99 Fifth Avenue Ottawa Urban Design Review Panel Resubmission Presentation
Formal Review

T h u r s d a y , M a y 3 , 2 0 1 8

Urban Design Review Panel Recommendations, January 11, 2018

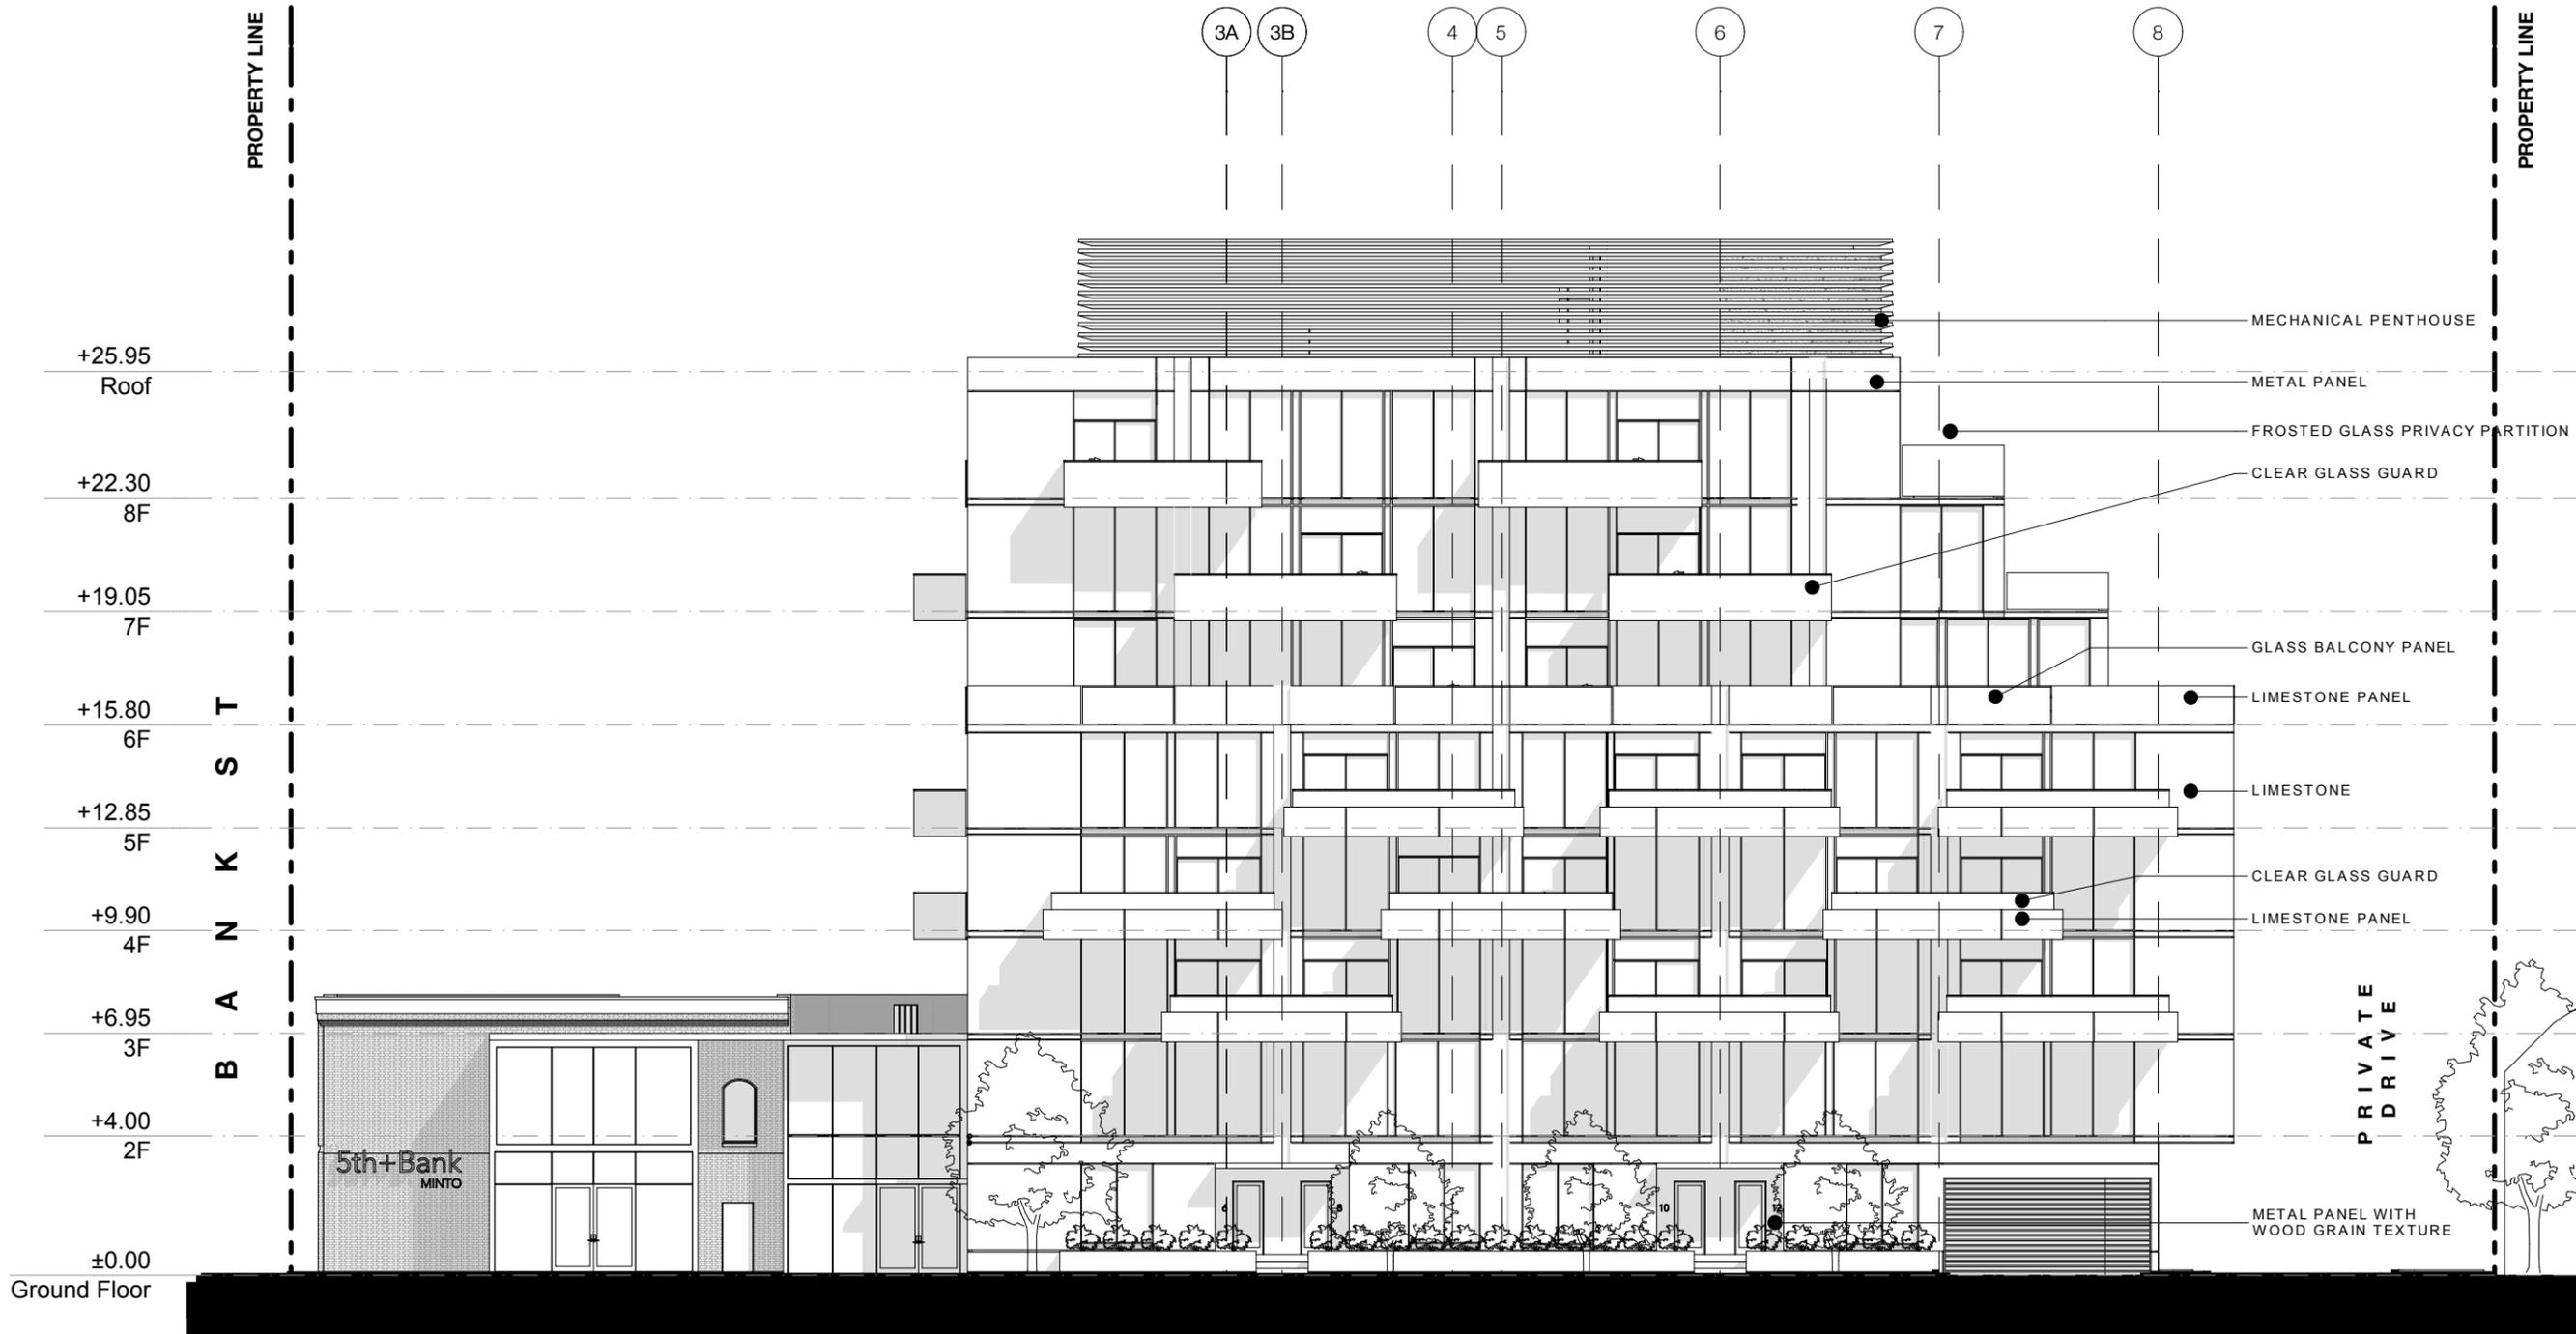
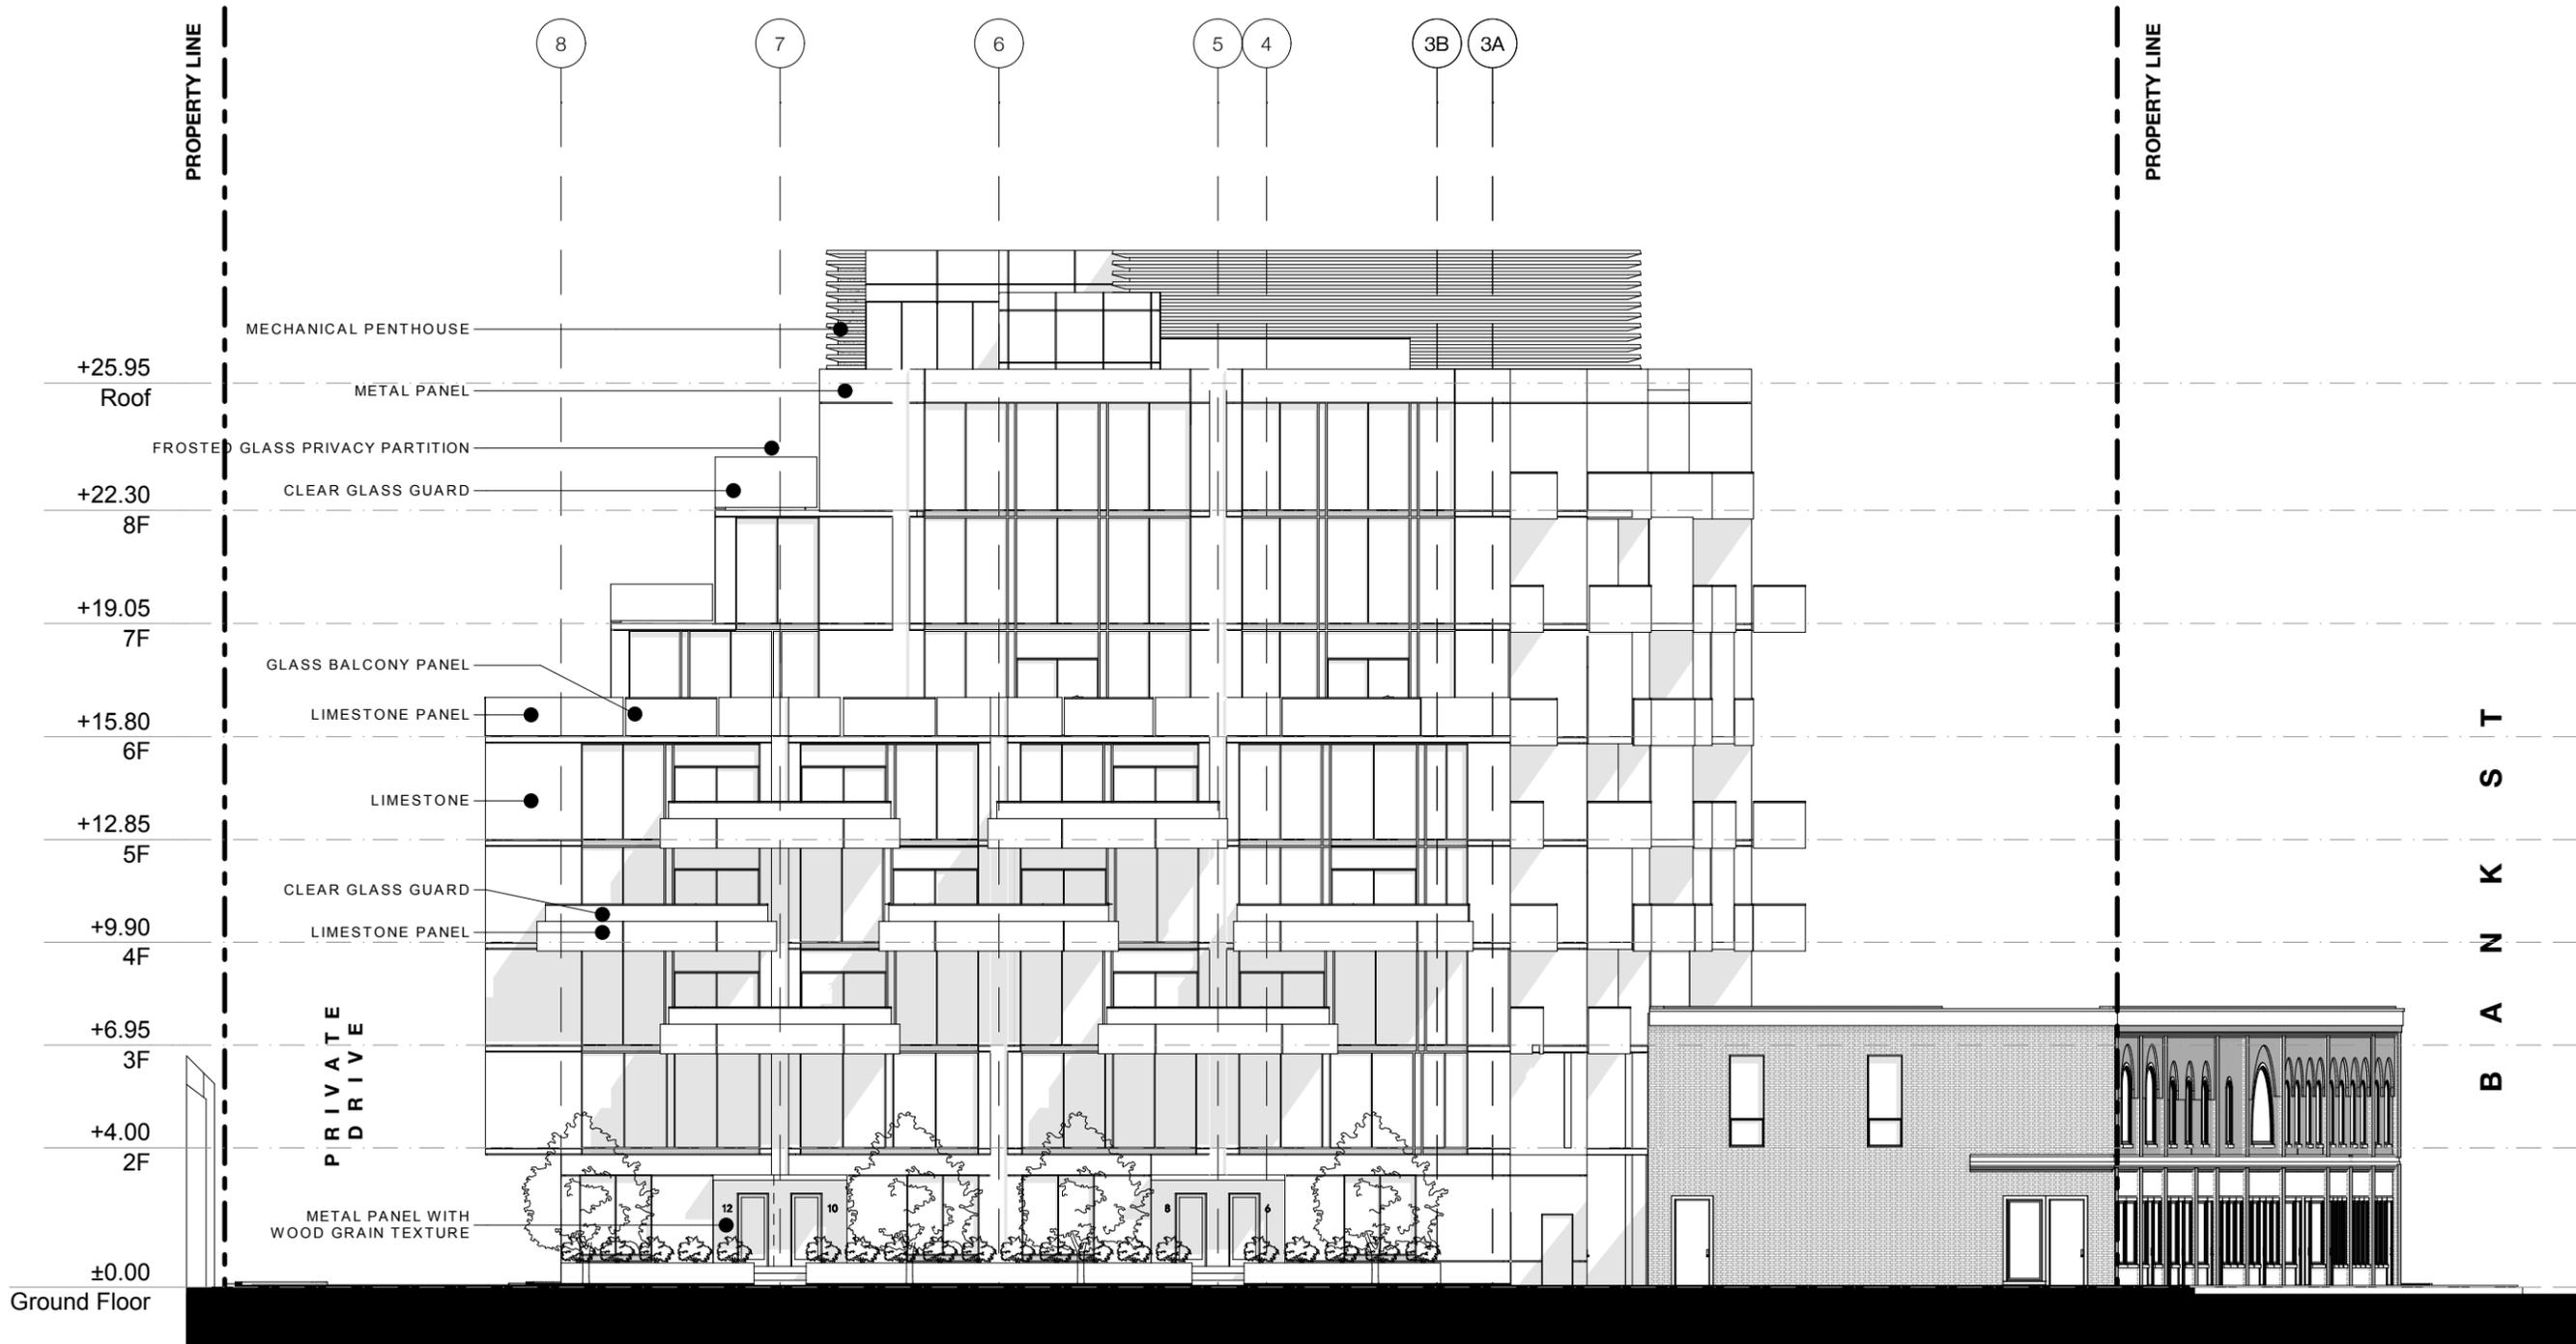
4 Establish a two storey datum line across both Fourth and Fifth Avenue facades that align with the houses in the existing area	A datum line was created and is consistent with the existing residential buildings. It is the average height of the houses along Fourth and Fifth Avenues. The floors above the second / third storeys are set back generally keeping with the fronts of the houses to the east.
5 Upper storeys above datum line should be recessed	The floors above the second / third storeys have been set back.
6 Concern with the contrast of the massing at the Northwest corner	A commercial lobby has been placed at the northwest corner of the building, creating an inset space breaking up the corner into smaller forms.
7 Balconies are distracting. Try and integrate them, making vertical bands more prominent, and establishing a simplified vertical alignment on north and south facades	All projecting balconies along Fourth and Fifth Avenues have been removed and integrated into the façade of the building. The massing along Bank Street has been simplified in keeping with the revised design.
